Ref: TR010063

3 September 2024

**Application by Gloucestershire County Council (the Applicant) for an Order Granting Development Consent for the M5 Junction 10 Highways Improvements Scheme**

**Submission from National Highways for Examination Deadline 4 (3 September 2024)**

Figure 2-1 Locations of Journey Time Routes 208 and 209

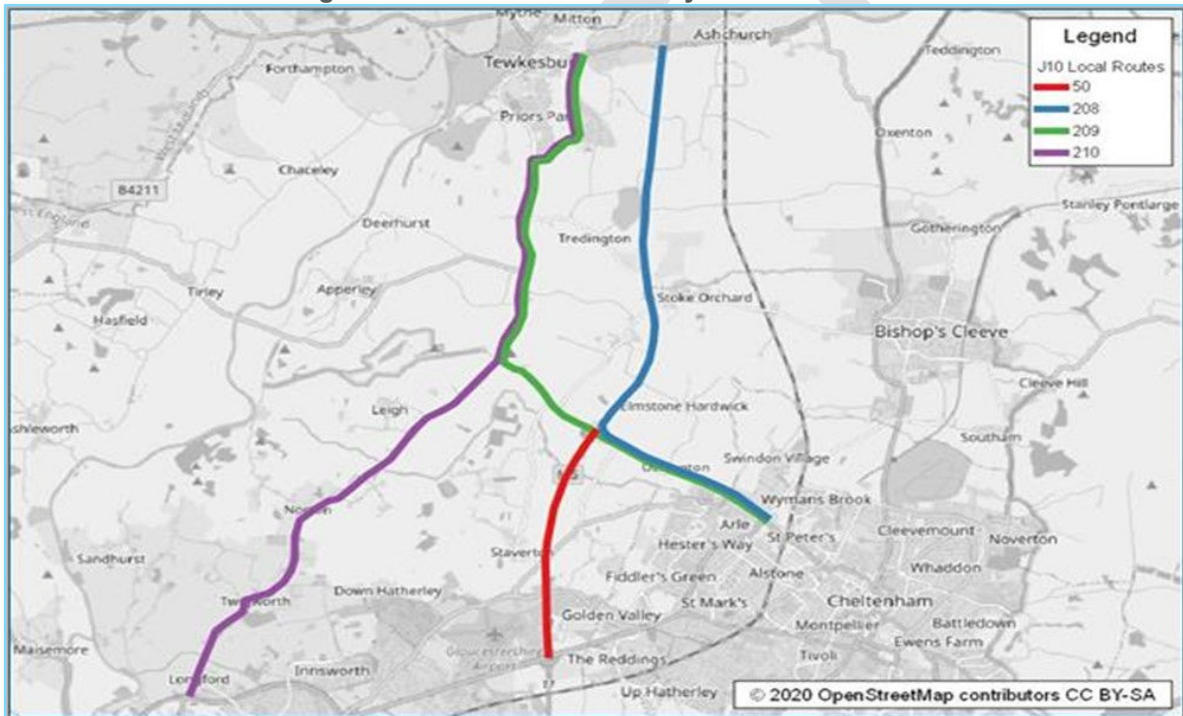
**Response:** As detailed above, paragraph 4.3.4 in TAG Unit M3.1 considers the localised aspects of the model. National Highways are of the view that the model is currently not considered to be fit for purpose due to the west/northbound journey time issues for routes 208 and 209 on the A4019. Until this issue is resolved, leading to a TAG compliant model, National Highways do not consider it a suitable model to support the DCO application. The routes are shown in Figure 9 of the aforementioned technical note that the Applicant prepared and is reproduced below.

Unless the two critical junctions are adjusted to bring the journey time validation within the appropriate 15% standard, it is not possible to confirm that the forecast model is reporting future traffic conditions appropriately.

In order for National Highways to be able to accept the SATURN model as being fit for purpose, and in line with National Highways requirements, the two journey time for routes, 208 and 209 in the northbound direction both need to meet the validation criteria required by TAG Unit 3.1 overall but specifically when considering only the section from the start of the route as far as the M5 Junction 10 as this represents the most critical section of the journey.
